Ref: GOOS3000

MINOR-MATERIAL AMENDMENT APPLICATION (SECTION 73)
UNIT 3A, EAST HORNDON BUSINESS PARK, TILBURY ROAD, WEST HORNDON

On behalf of our client, Goodman, we are pleased to submit an application for a Minor-Material Amendment (Section 73) in relation to full planning permission ref. 22/01751/FUL which approved the construction of a Class B2 / B8 building at the site Land South of East Horndon Hall, Tilbury Road, West Horndon, Essex, CM13 3LR.

DRAWING NUMBER
31795-FE-13F

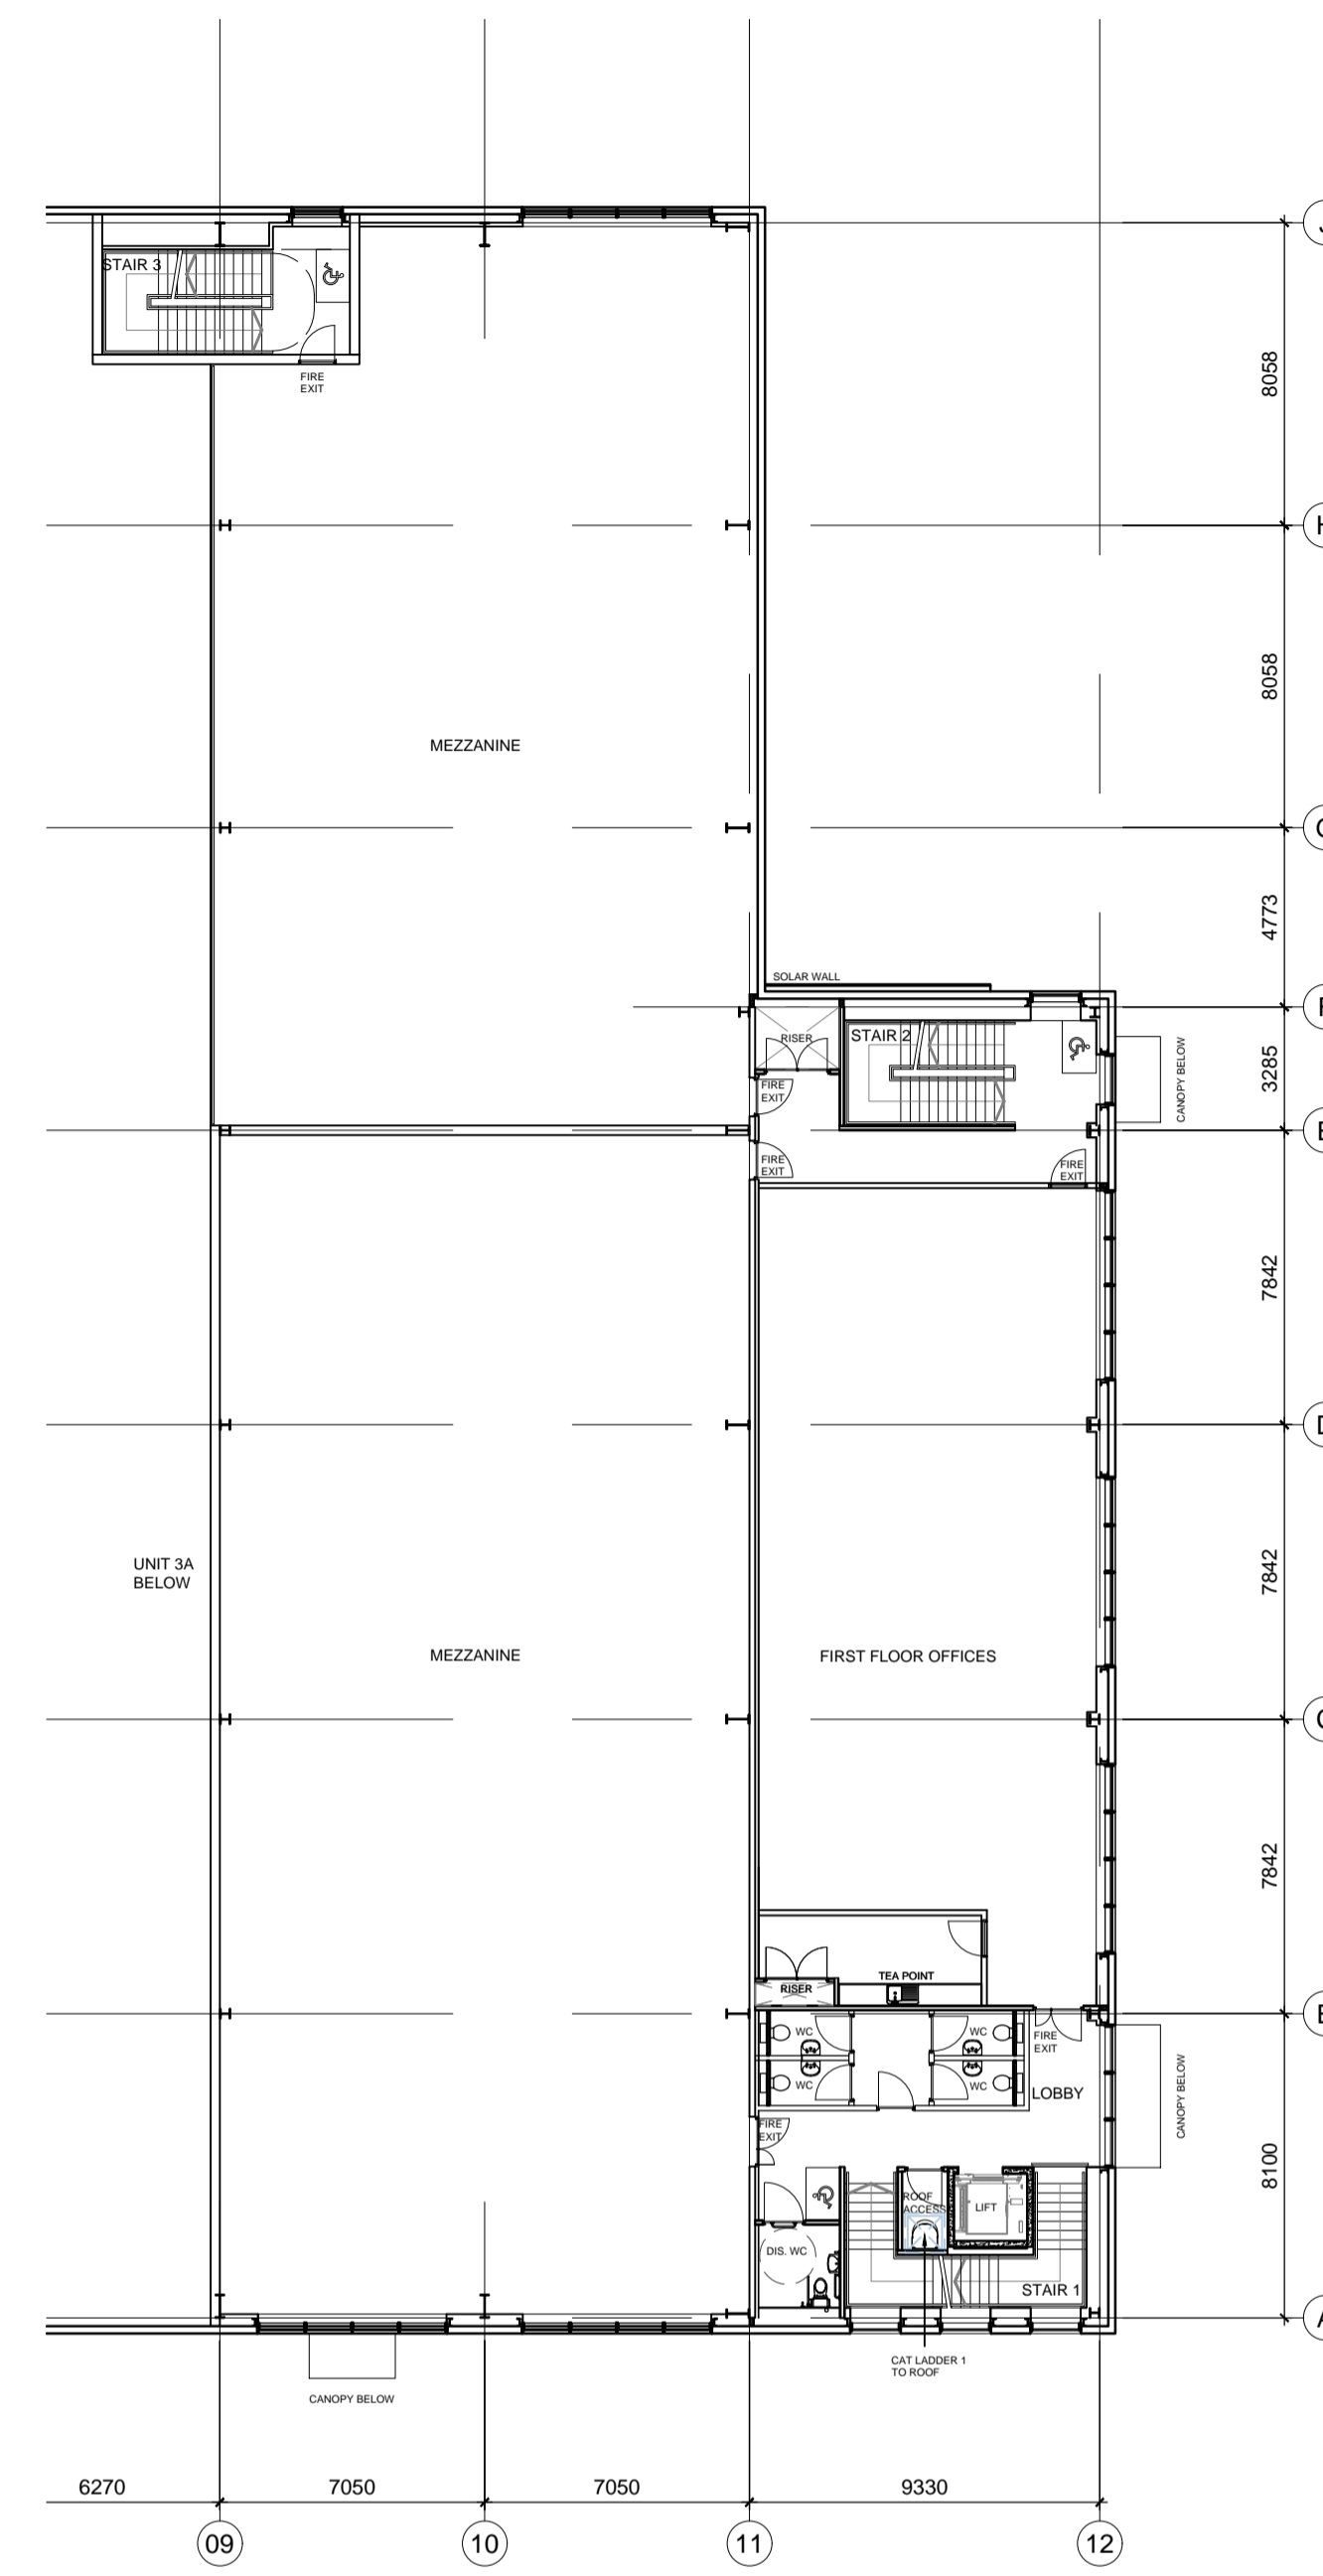
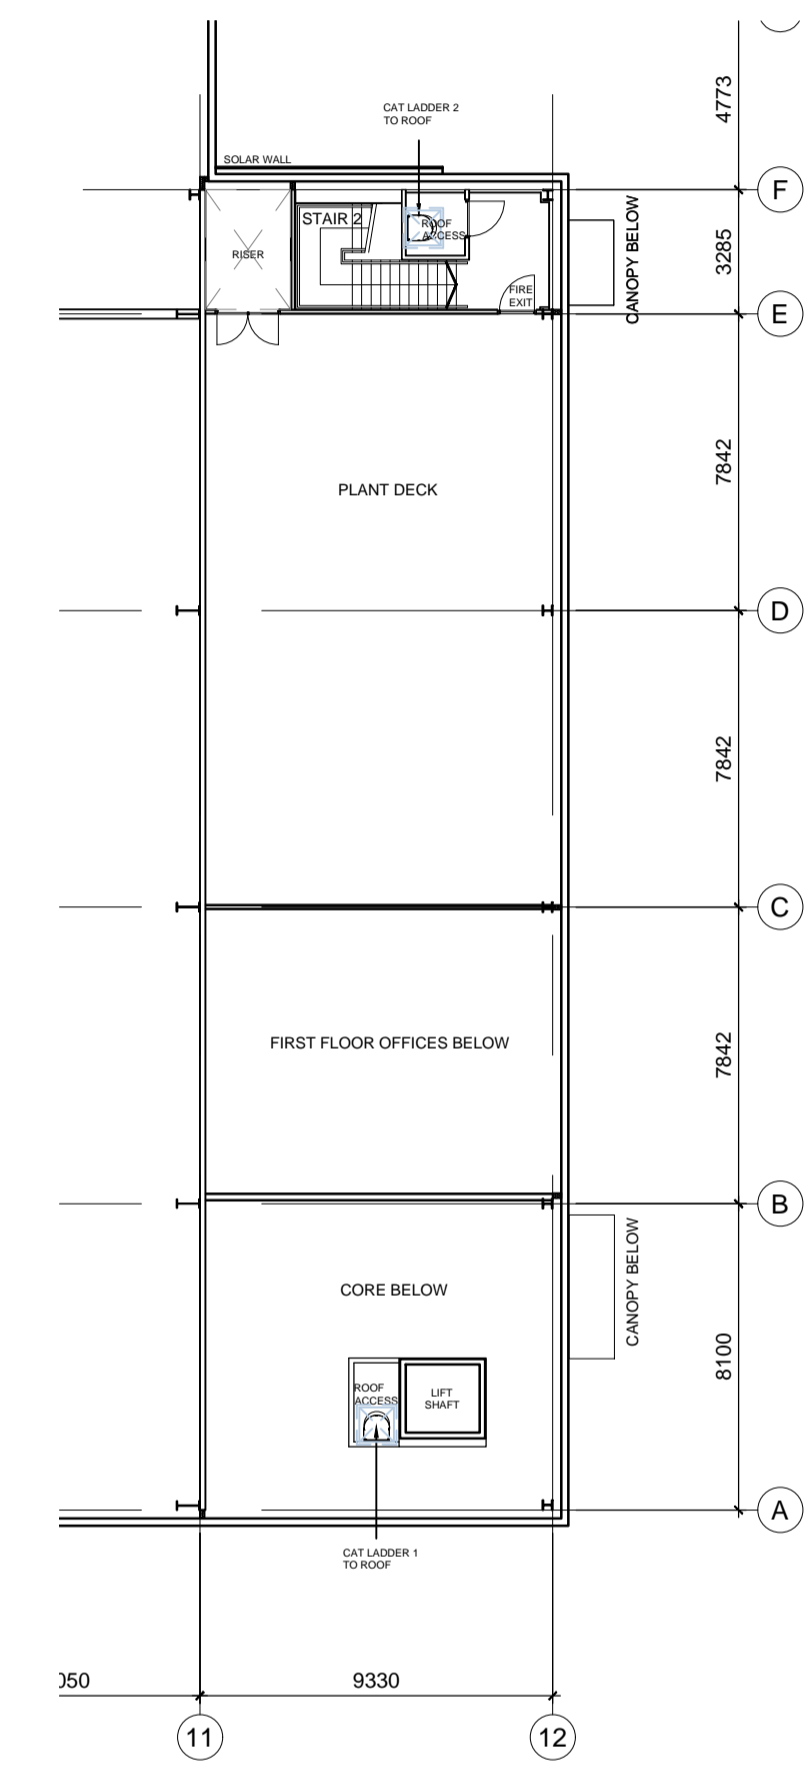
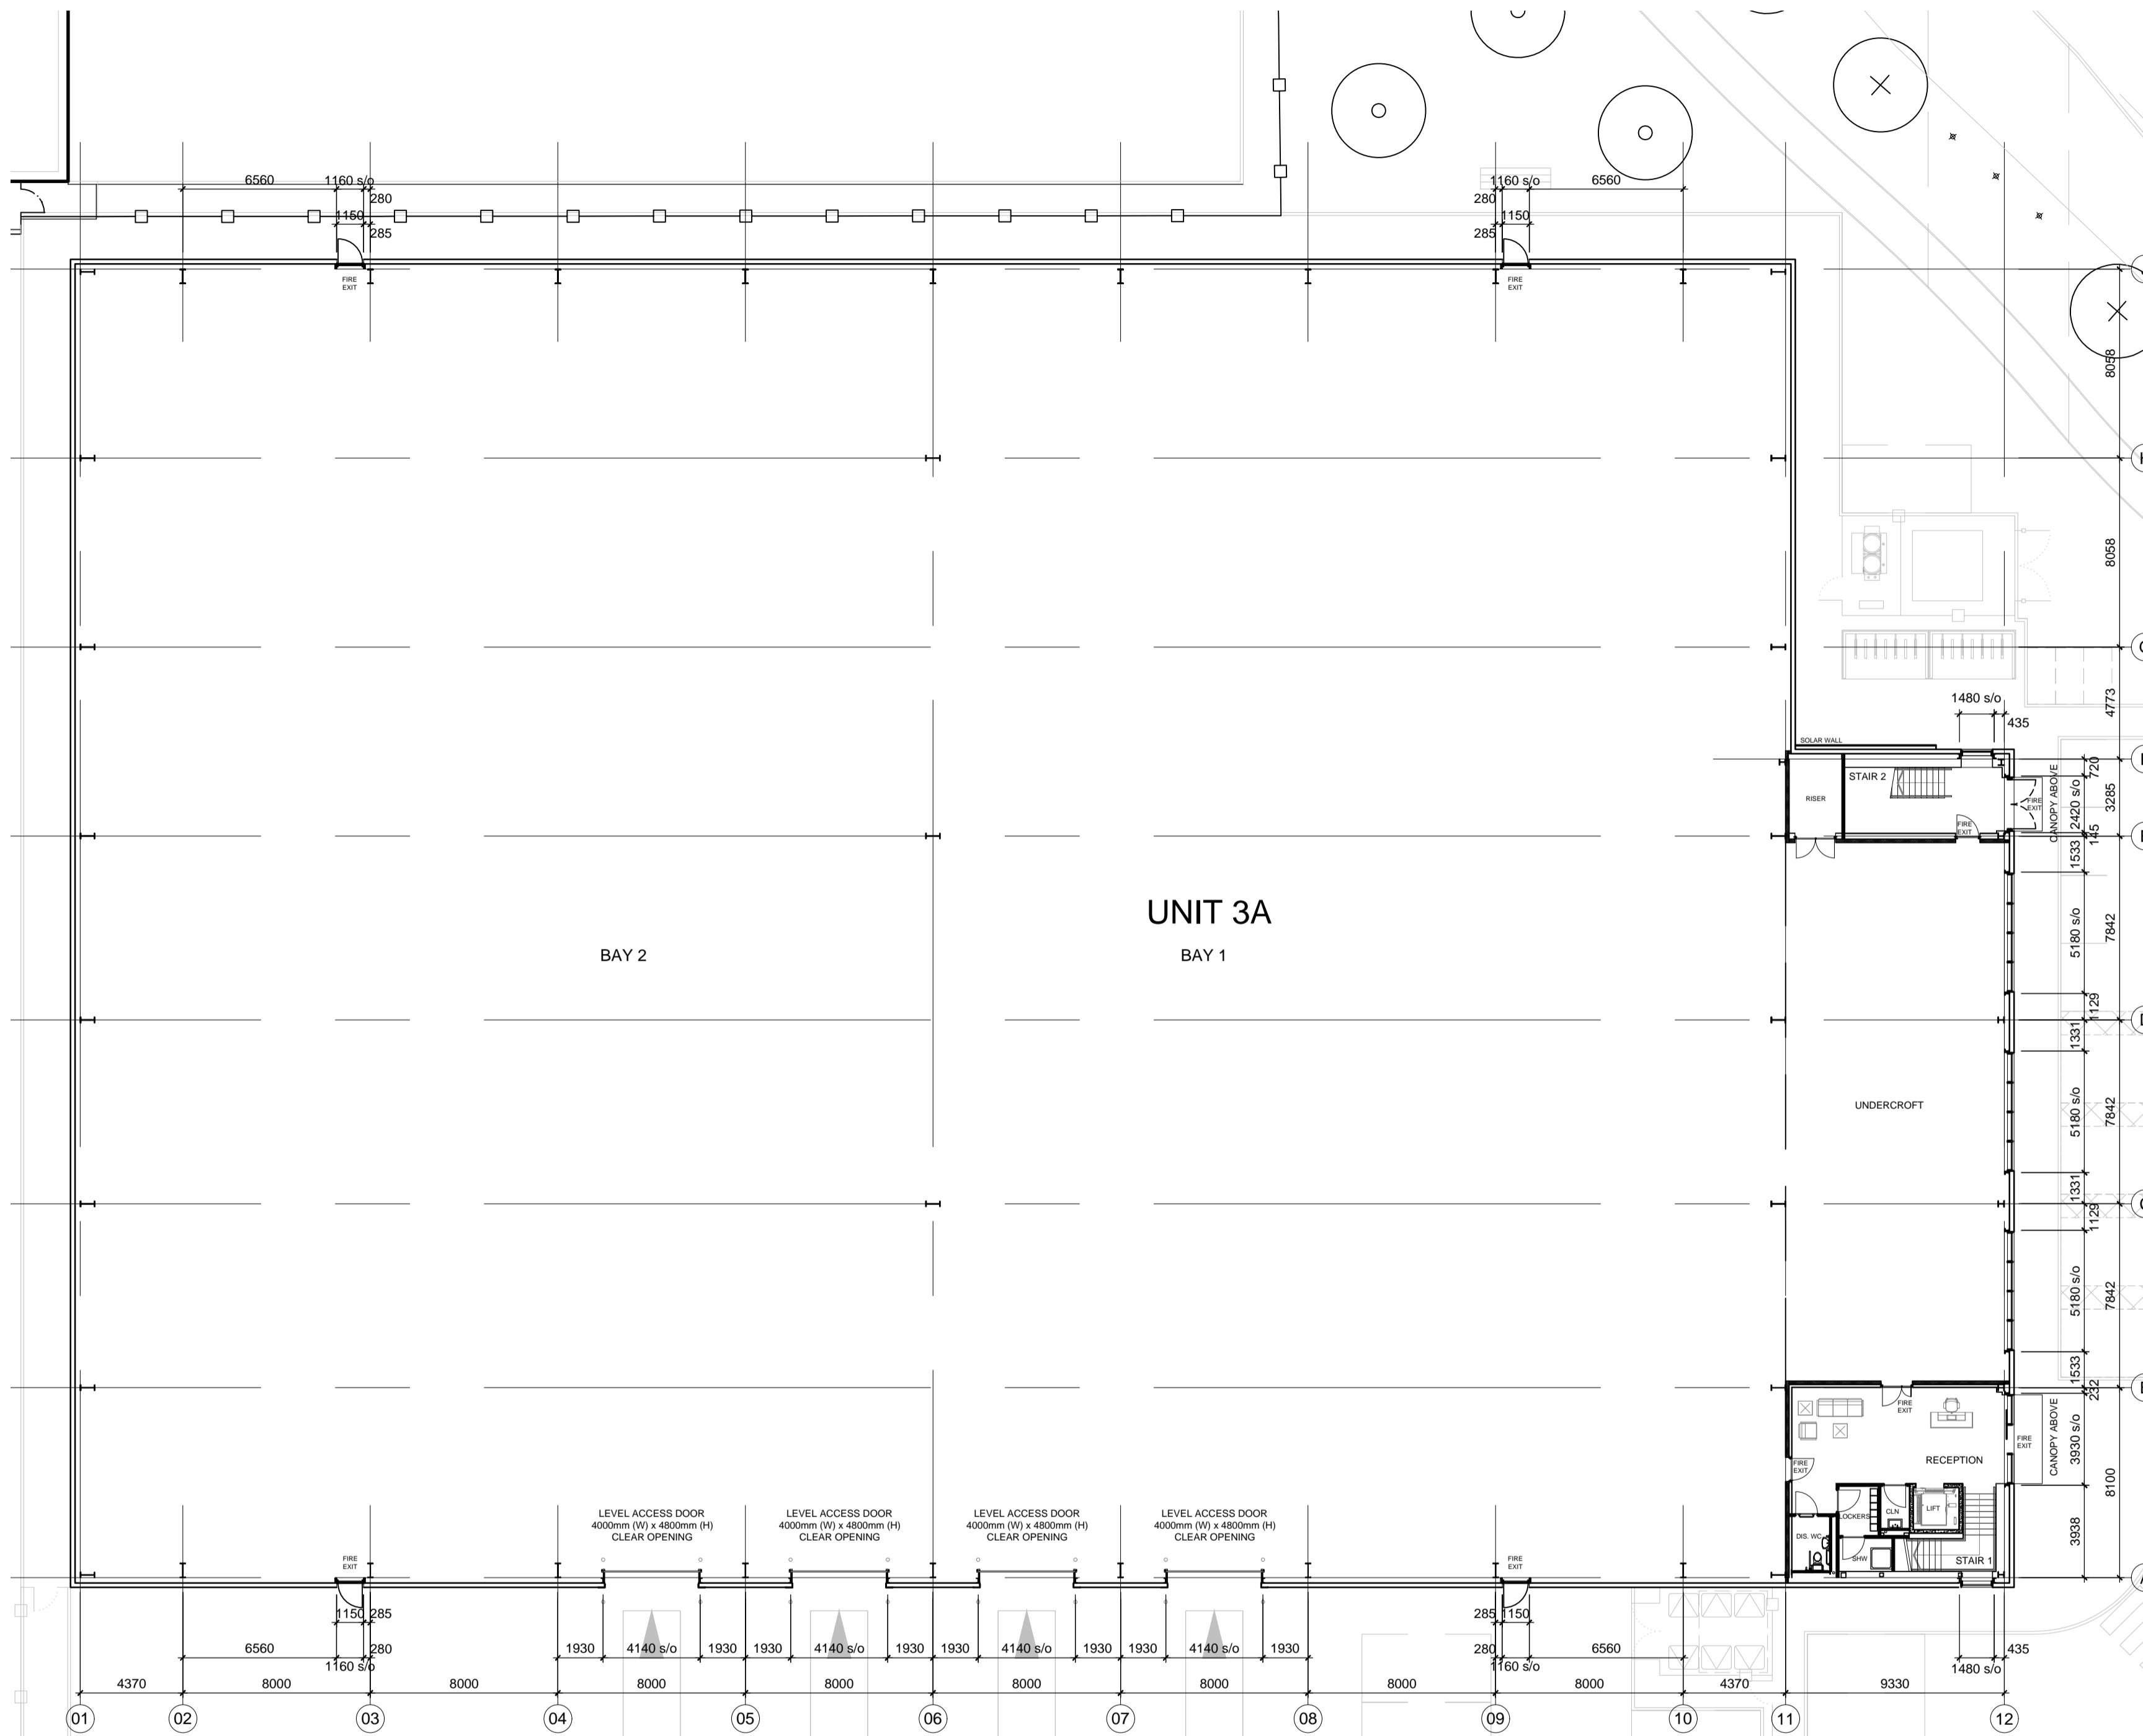
The new occupier requires an enlarged mezzanine area in order to provide additional flexibility for future operations within the building. The mezzanine also takes into account minor changes to the internal configuration of the ground floor including the formation of an ancillary customer area. This change is internal only and does not affect the external appearance of the building.

It is acknowledged that this internal change will result in an increased area of floorspace, with the addition of 774 sqm, resulting in a total building floor space of 5,496 sqm.
